Recommendation Report for Planning Permission

REF NO:	LU/133/19/PL
LOCATION:	Site of Inglecroft Barn Close Littlehampton West Sussex
PROPOSAL:	Application for full planning permission for the demolition of the existing vacant dwelling and workshop and the erection of 10 detached dwellings (9 dwellings net).

DRIVE DETAIL
SCALE 1:10

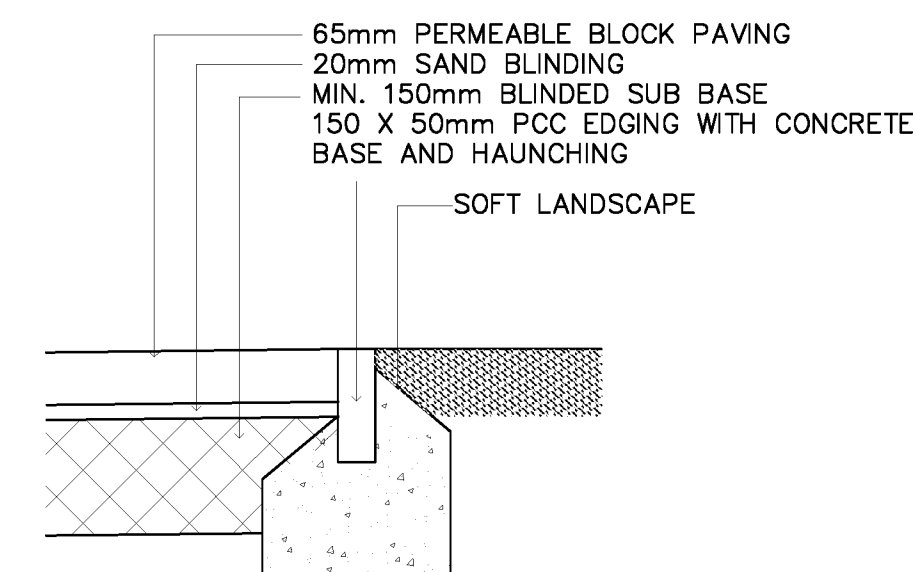
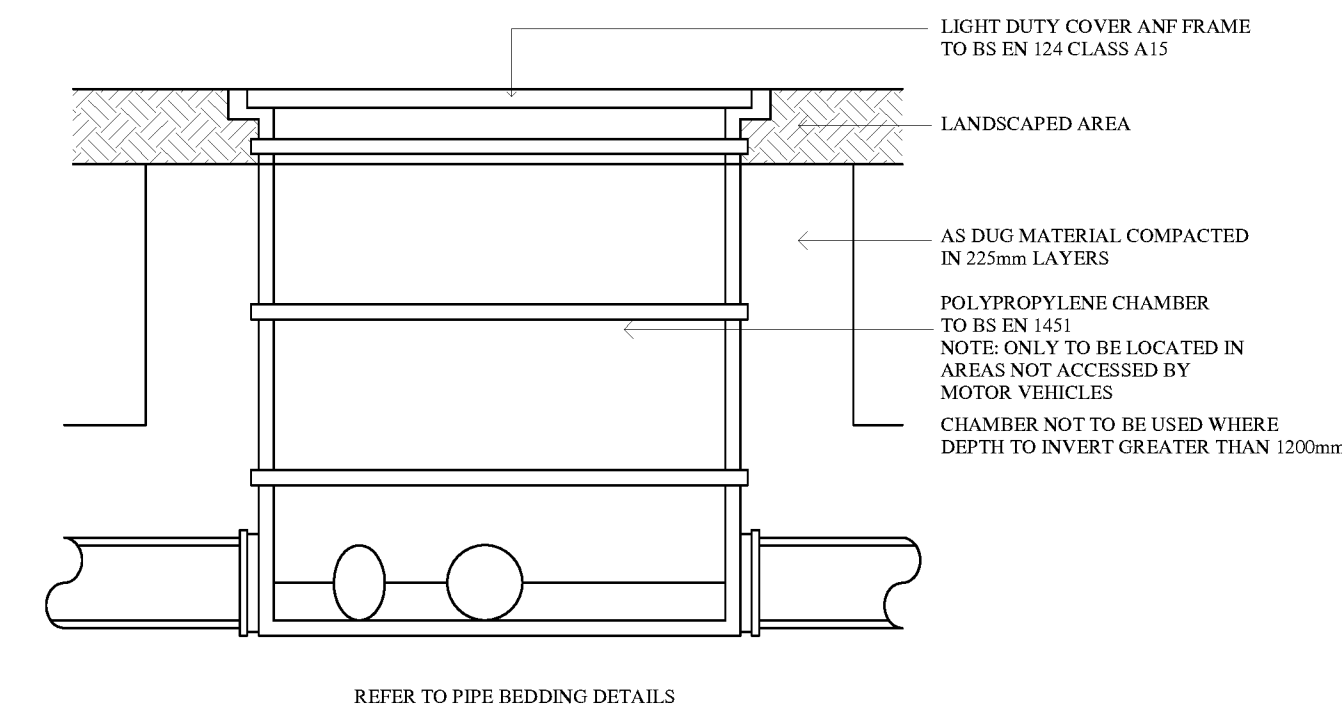
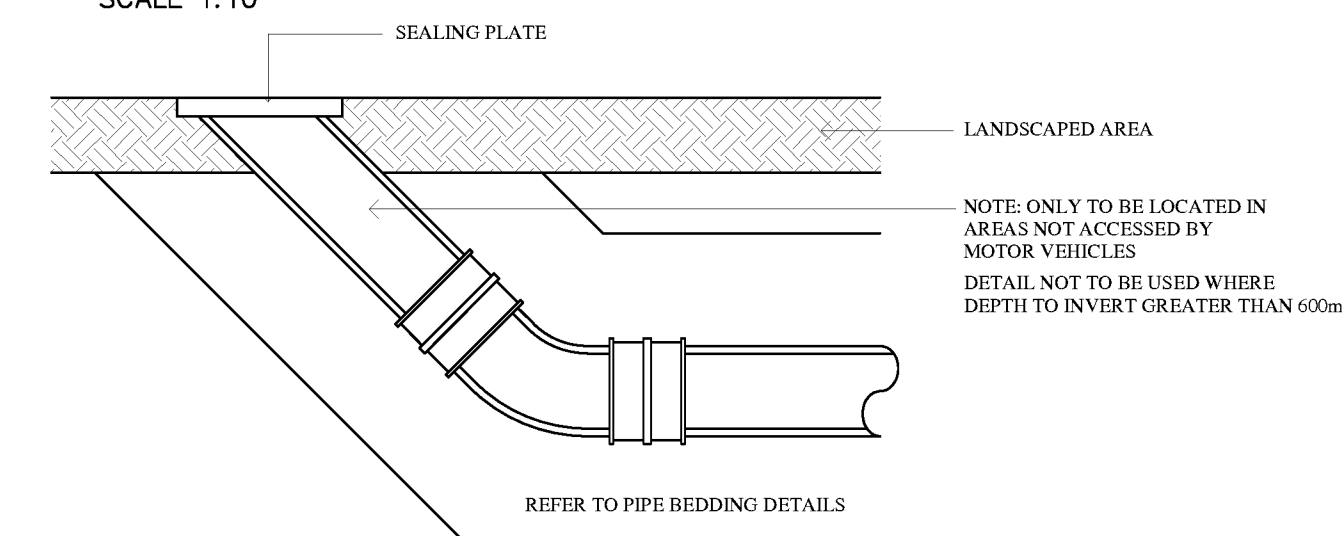
7. The construction detail drawing of the soakaways does not clearly identify cover depth requirements over crates.

8. Construction detail drawings need to be submitted of manholes, pipe bedding details, and silt traps.
